Mayberry Phase 1
Amendment to the Ellicott Town Center
Phase 1 PUD/Preliminary Plan
Transportation Memorandum
PCD FILE NO.: PUDSP219
(LSC #S214300)
October 22, 2021

Mayberry Phase 1 PUD Amendment Transportation Memorandum

RE: Mayberry Phase 1
Amendment to the Ellicott Town
Center Phase 1 PUD/Preliminary Plan
El Paso County, CO
Transportation Memorandum
EPC PCD File No.: PUDSP219
LSC #S214300

**TYPICAL URBAN LOCAL ROAD SECTION - 60' ROW** (URBAN LOCAL)  
SCALE: 1"=5' H  
1"=2.5' V

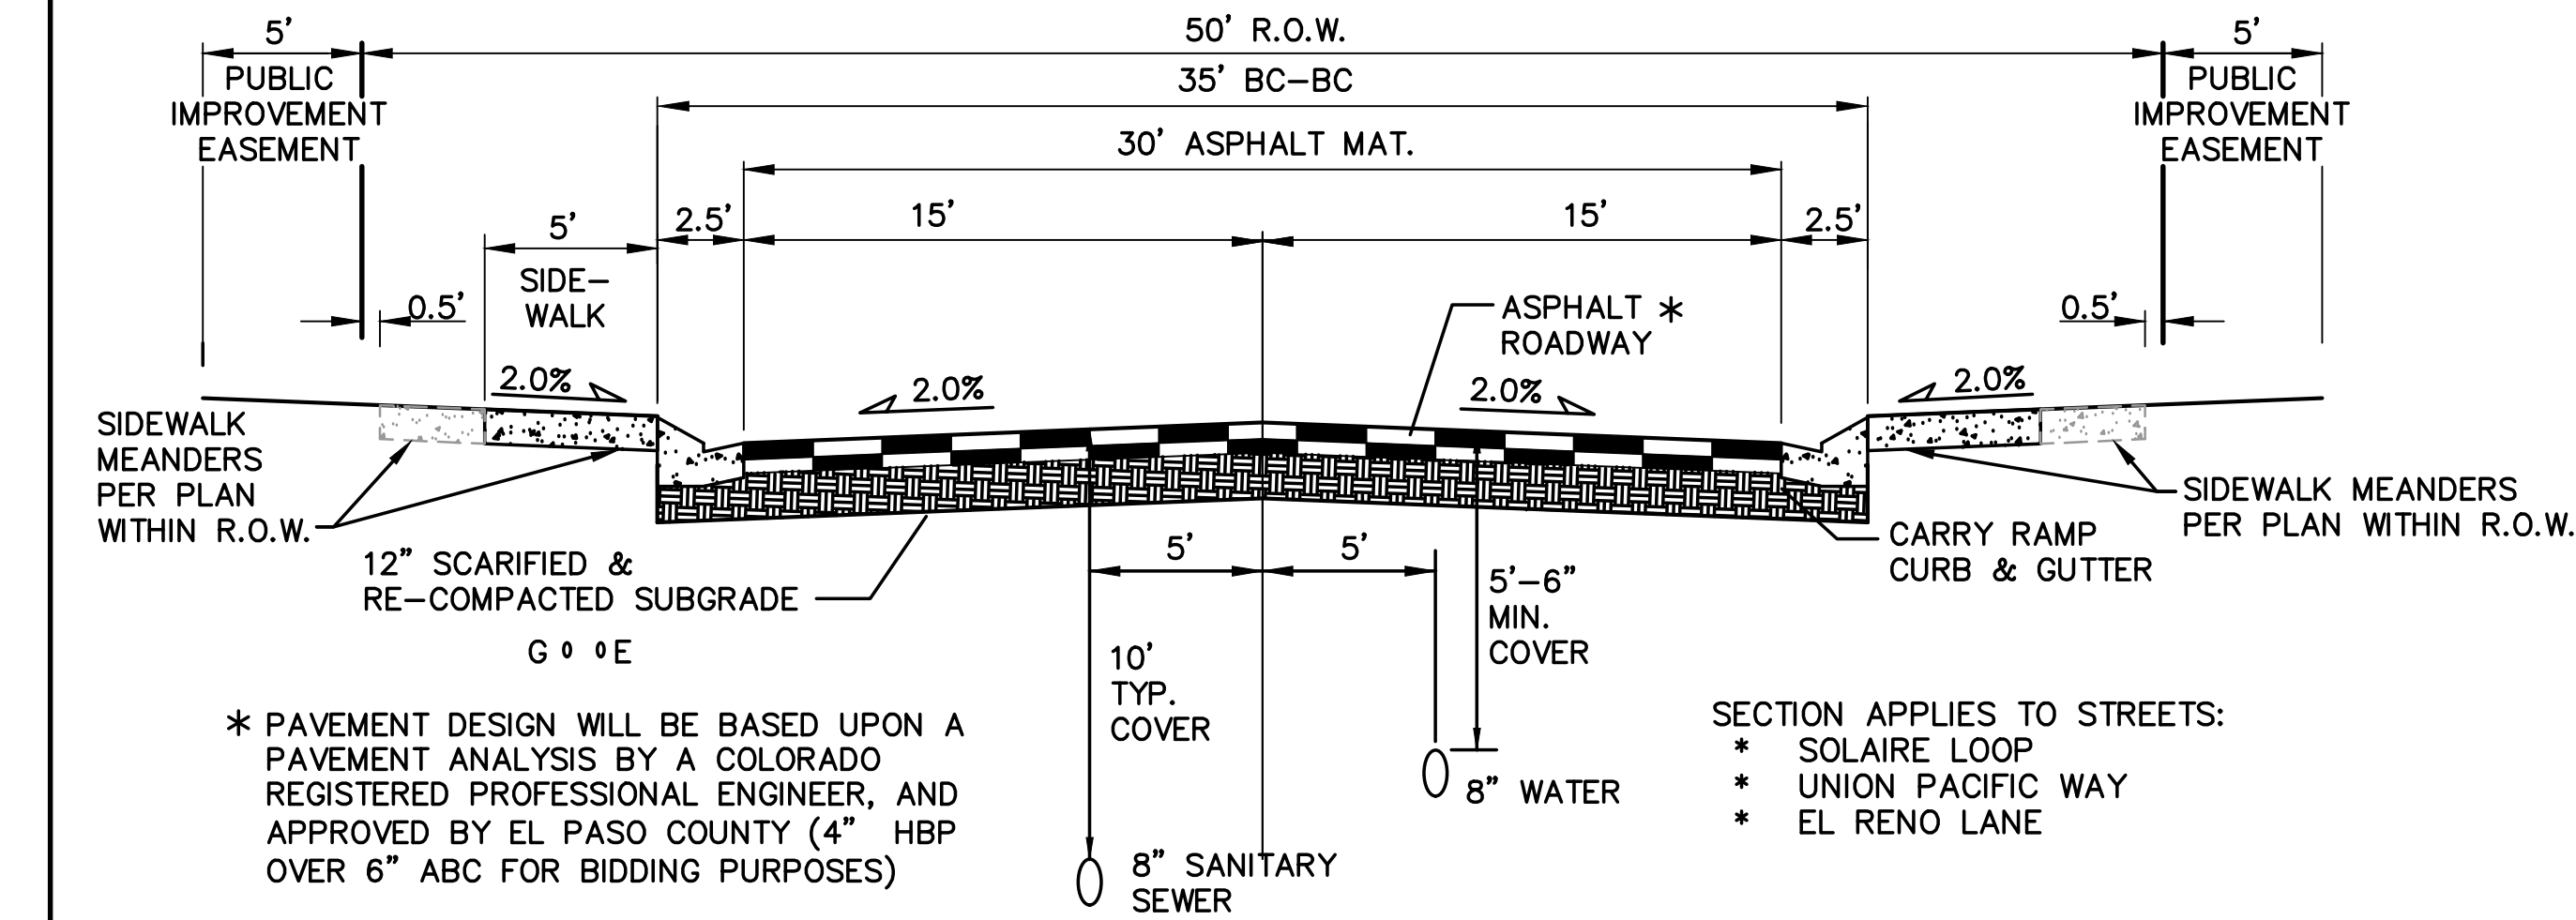
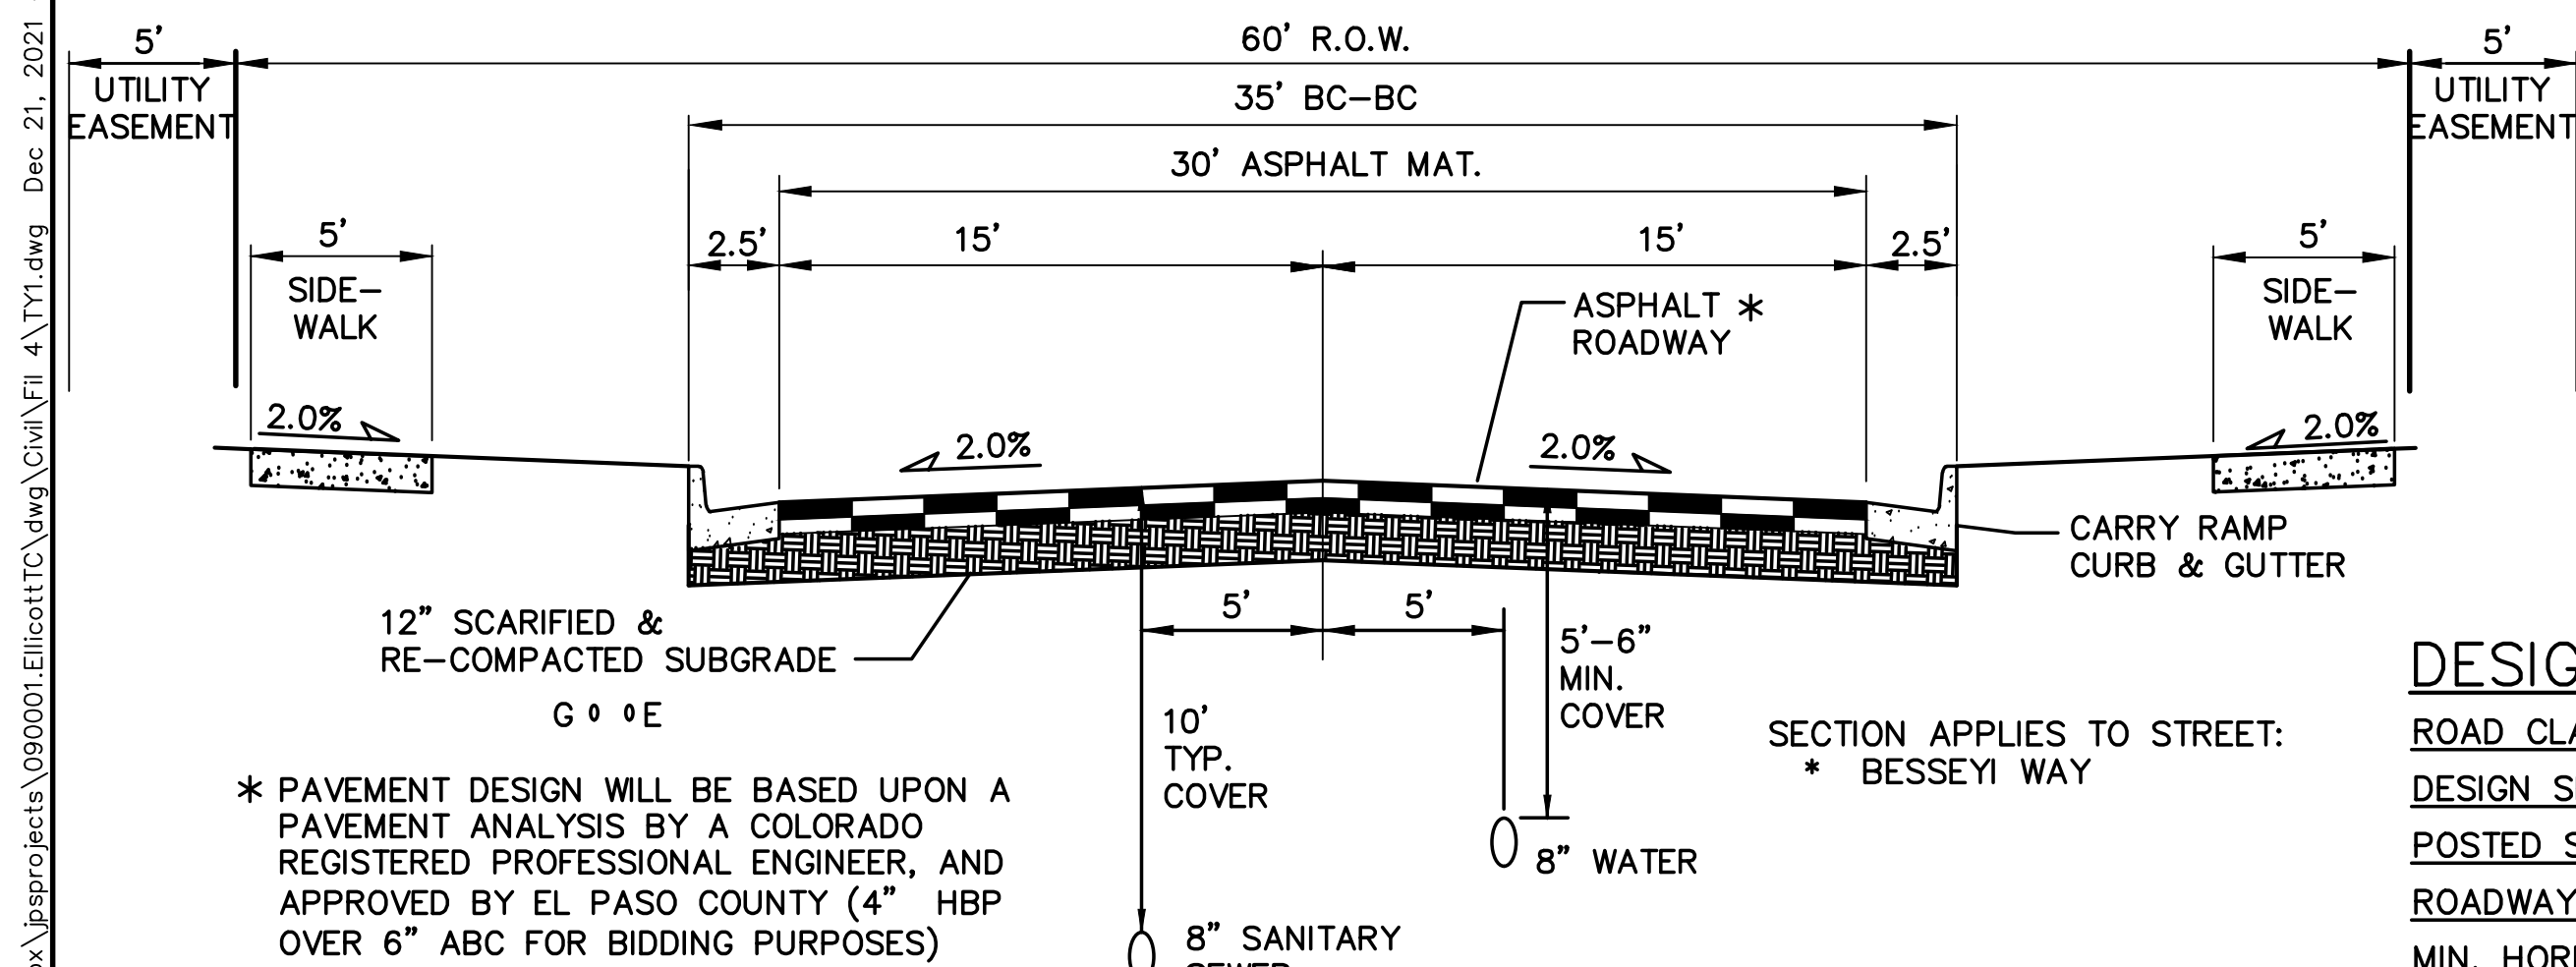
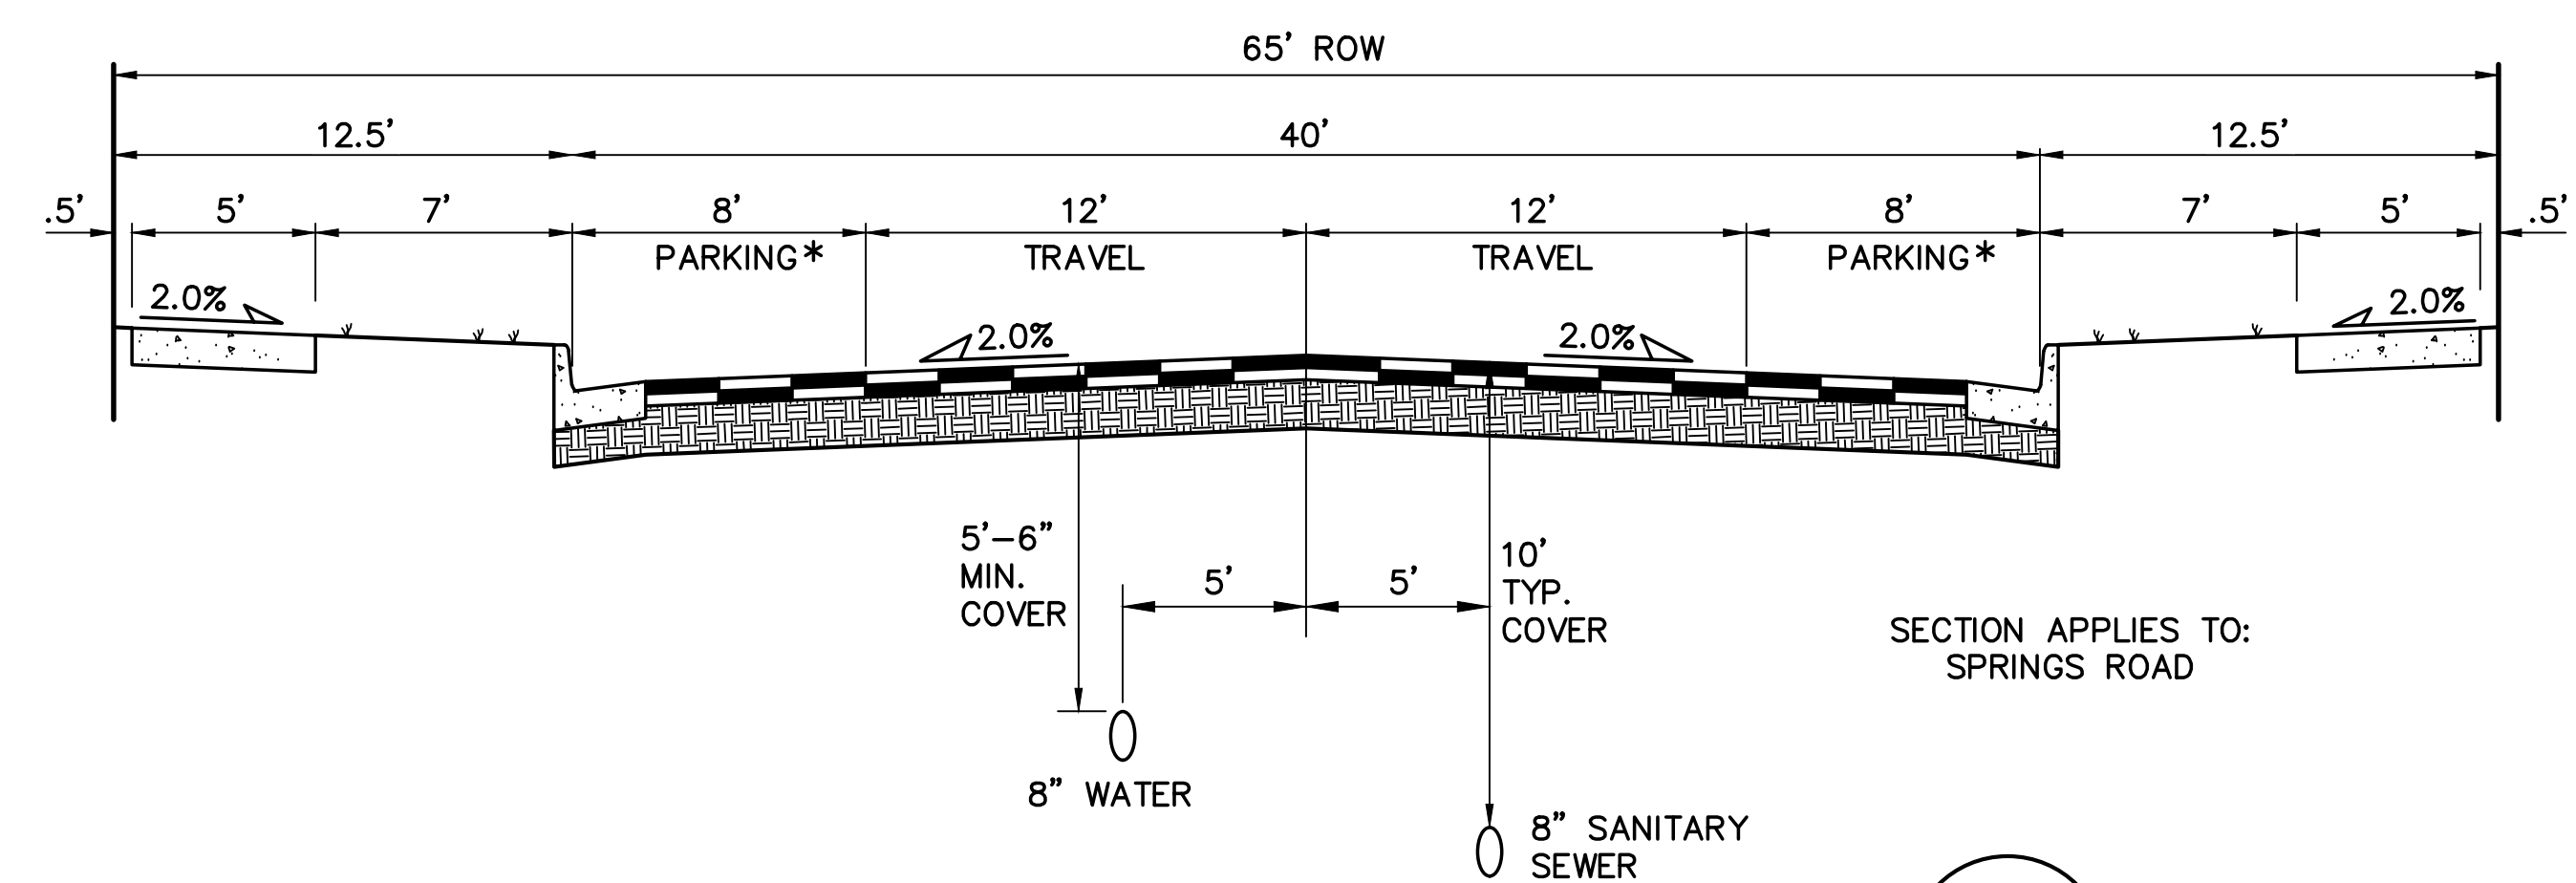
Please identify that the ROW provided is still 60' for the segment through the residential areas (matching the previous deviation) and that the urban local roadway also identifies a 30 ft. asphalt width. If there are any differences in the proposed roadway section please identify them for review.
